Recommendation Report for Planning Permission for Works or Extension to a Dwelling

REF NO: FP/253/19/HH

LOCATION: 11 Fittleworth Drive
Felpham
PO22 6QE

PROPOSAL: Proposed single storey front & side extension, new rooflights and covered porch.

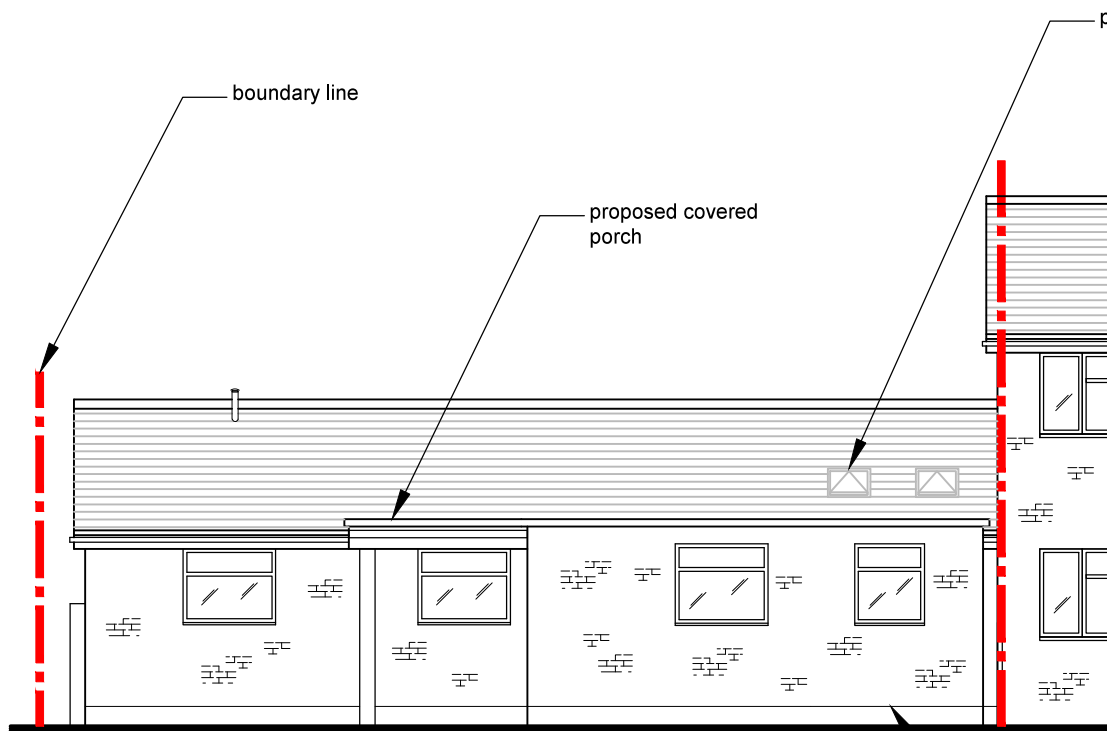
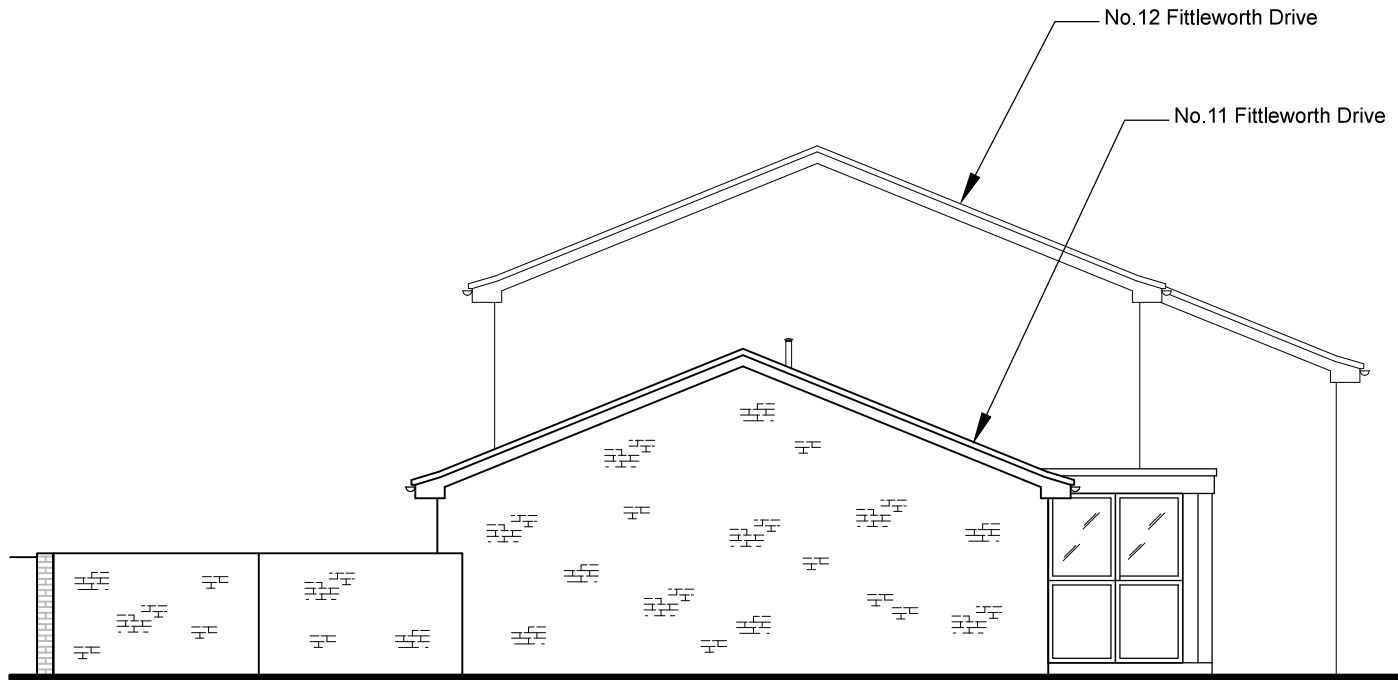
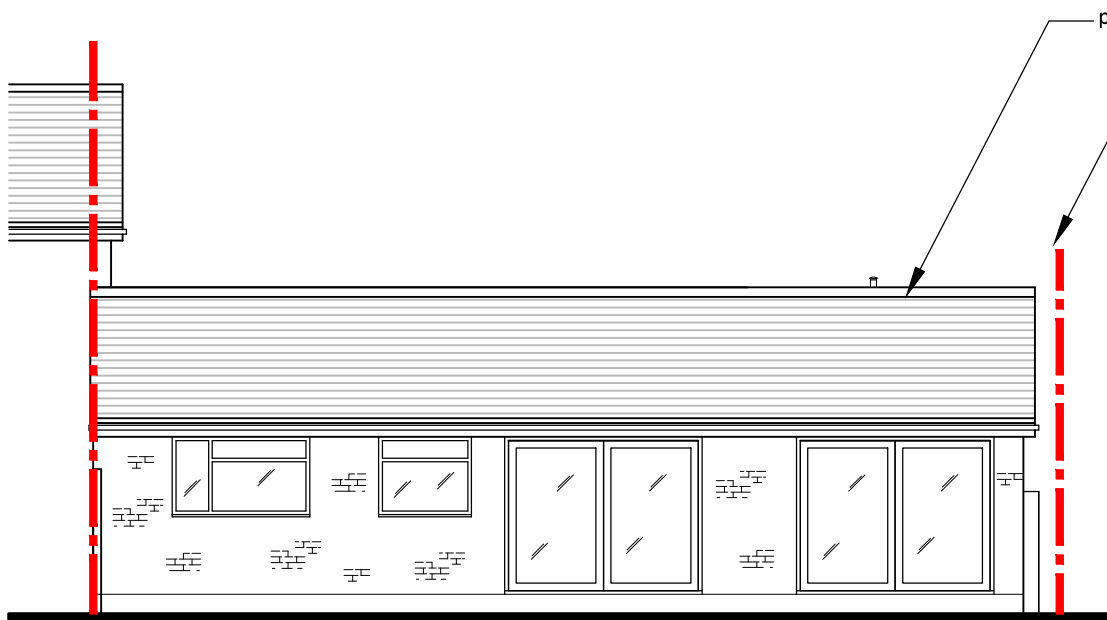
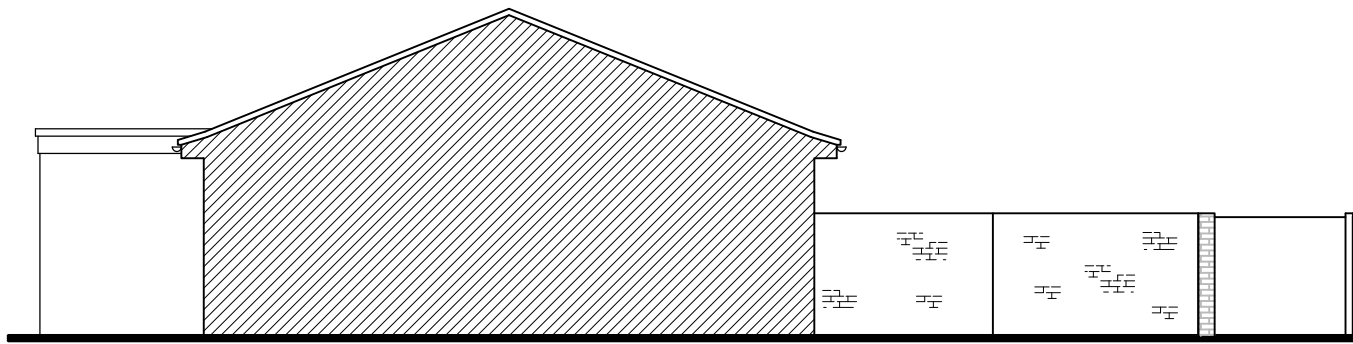
The side extension will sit at the same the ridge height of the dwelling and therefore is not considered subservient as it is a significant addition. The development will alter the appearance of the dwelling however, the extensions and front porch have been constructed to appear sympathetic in design and appearance to that of the host dwelling and surrounding properties.

The side extension will have a depth of 8.25m and a width of 3.8m with a height of 4.5m to match the existing property which also has an eaves height of 2.5m which is going to be matched with the new extension. The proposed side extension is not deemed to result in adverse overbearing, overshadowing or overlooking impacts upon this elevation. As there is 0.6m to the boundary then a further 1.9m to the road. This is deemed to be an acceptable distance that will not have a significantly adverse impact on the character of the area.

The front extension will have a width of approximately 2.6m, depth of 2.2m and a height of 2.7m with a flat roof. The space created by this is to allow for the creation of an ensuite to the bedroom. With the side extension having an eaves height that is higher than that of the existing dwellinghouse it is not
